Please ask for: Ms Iqraa Malik
Email: iqraa.malik@terraquest.co.uk
Telephone: 01212341390
Our Ref: FG/173/20/HH
Your Ref:
Date: 12th January 2021

Application for Planning Permission for Works or Extension to a Dwelling

Development: Addition of a single storey 'cube' glass room to the rear elevation of the property in the private garden
Location: 31 Ferringham Lane Ferring BN12 5NB

Block Plan shows area bounded by: 509238.49, 102159.03 509328.49, 102249.03 (at a scale of 1:500), OSGridRef: TQ 928 220. The representation of a road, track or path is no evidence of a right of way. The representation of features as lines is no evidence of a property boundary.

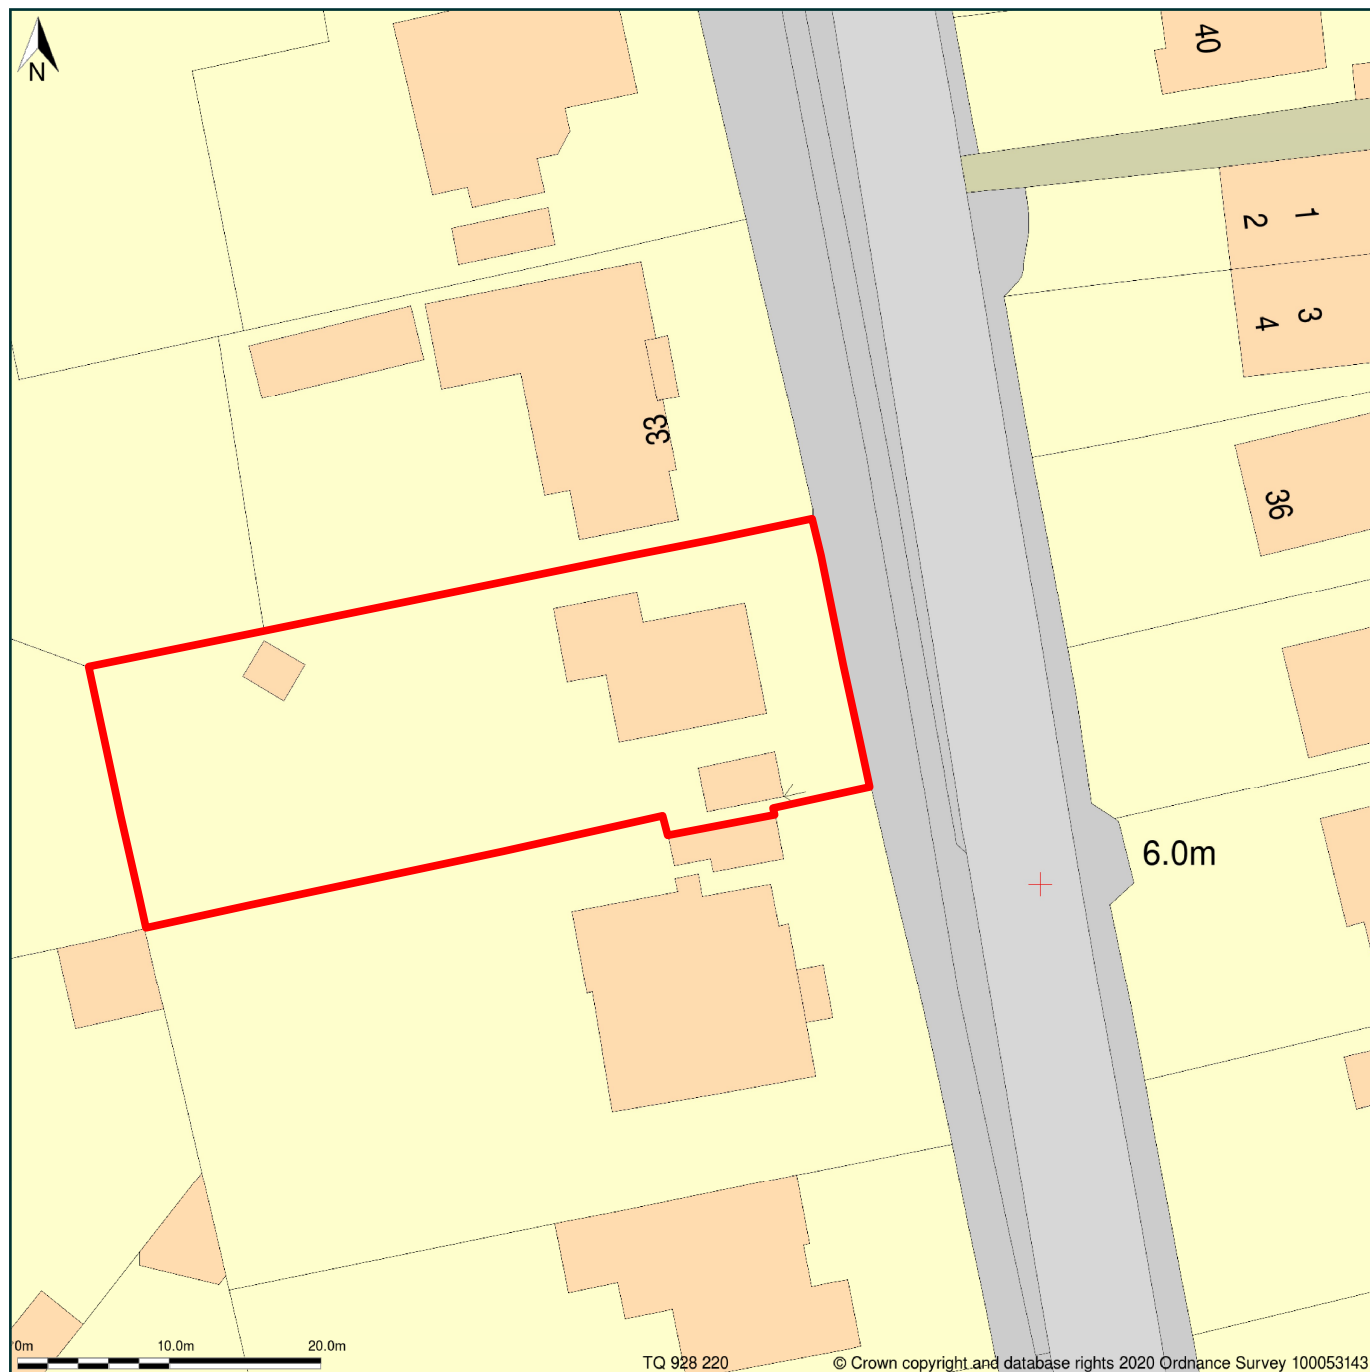
Block Plan

You are required to have dimensions from the proposed extension(s) to all site boundaries. Please amend.

**Plans
As Proposed
(Phase 2)**

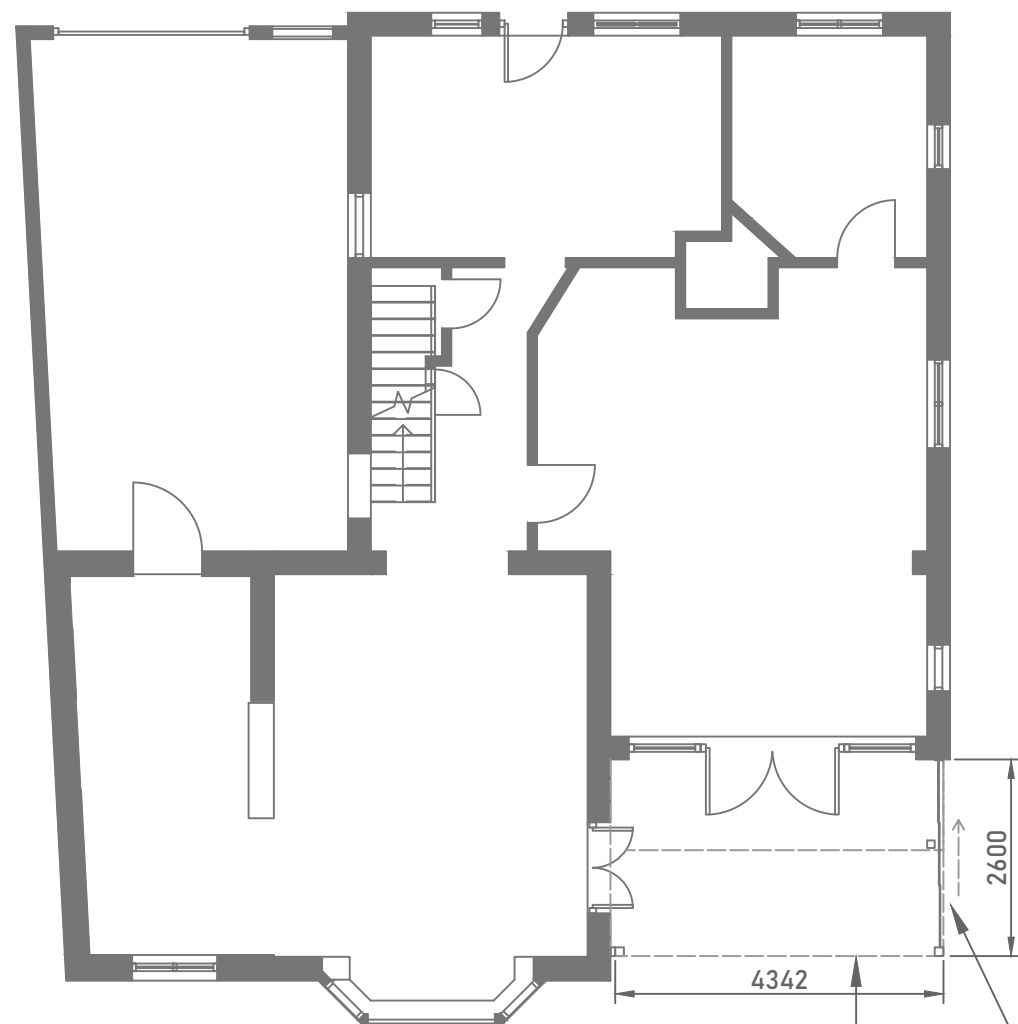
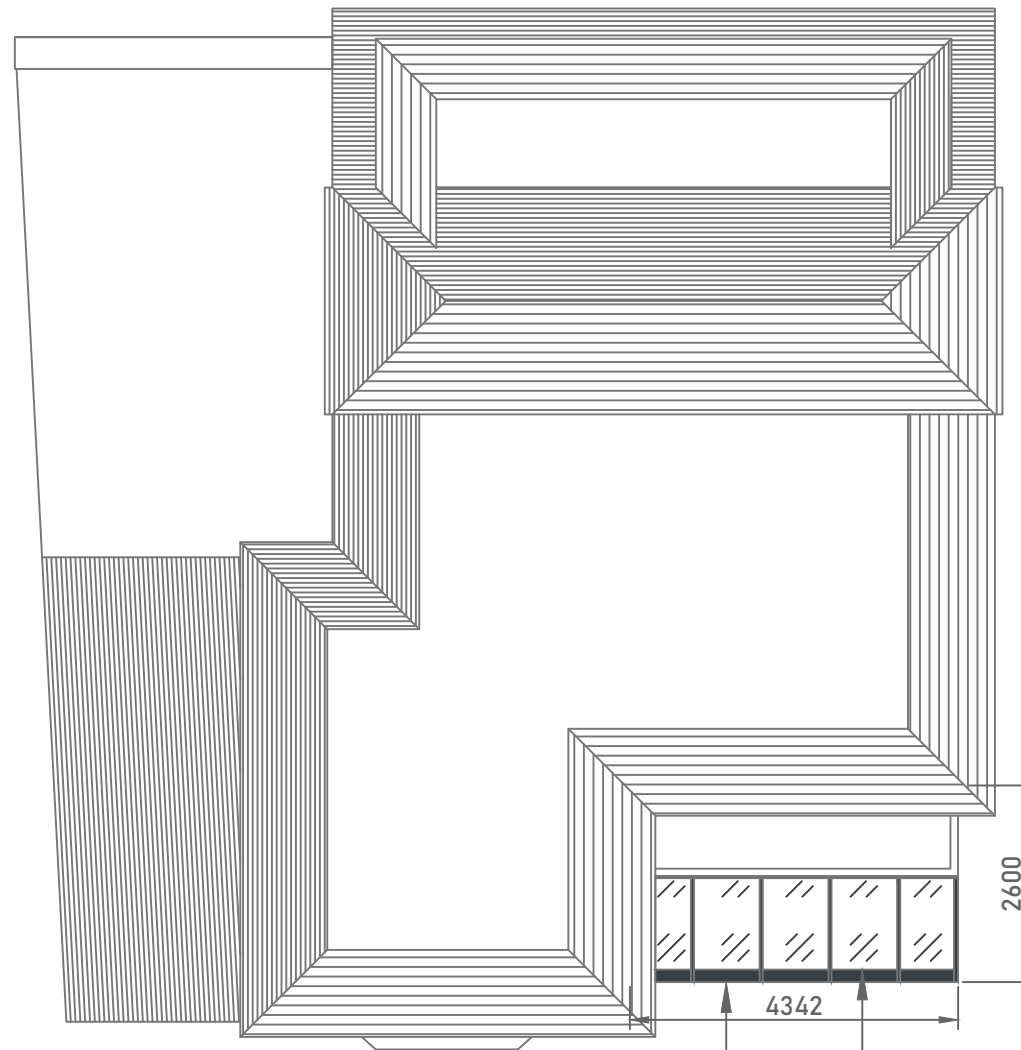
Please add room labels to all floor plans.

drawing title
**Elevations
As Proposed
(Phase 1)**

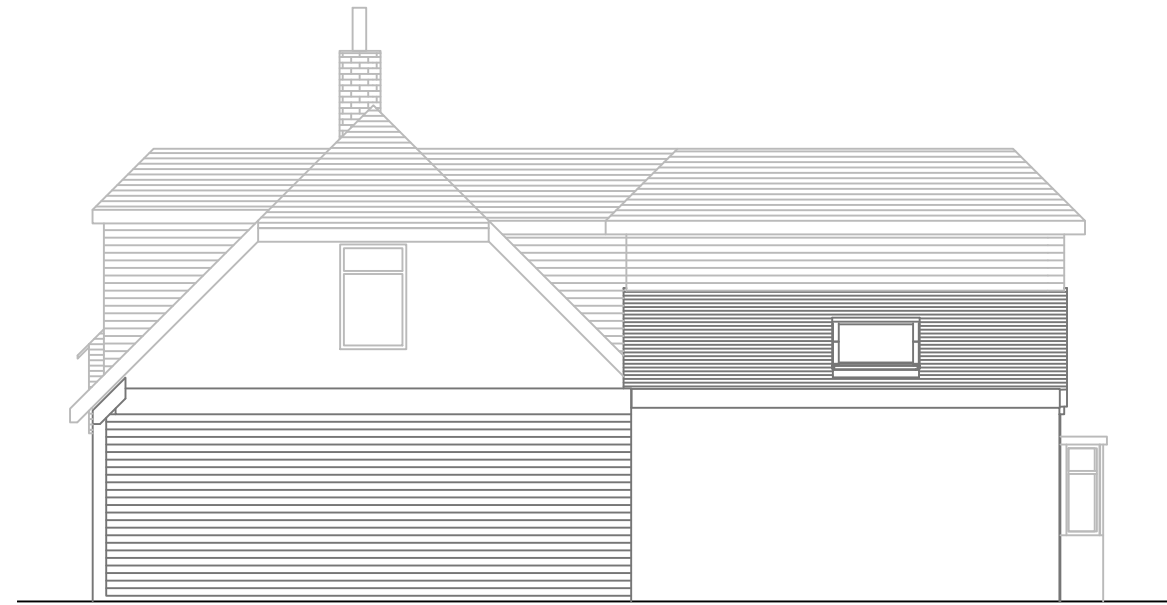
The building lines on the side elevations are inconsistent with the floor plans. Please amend.
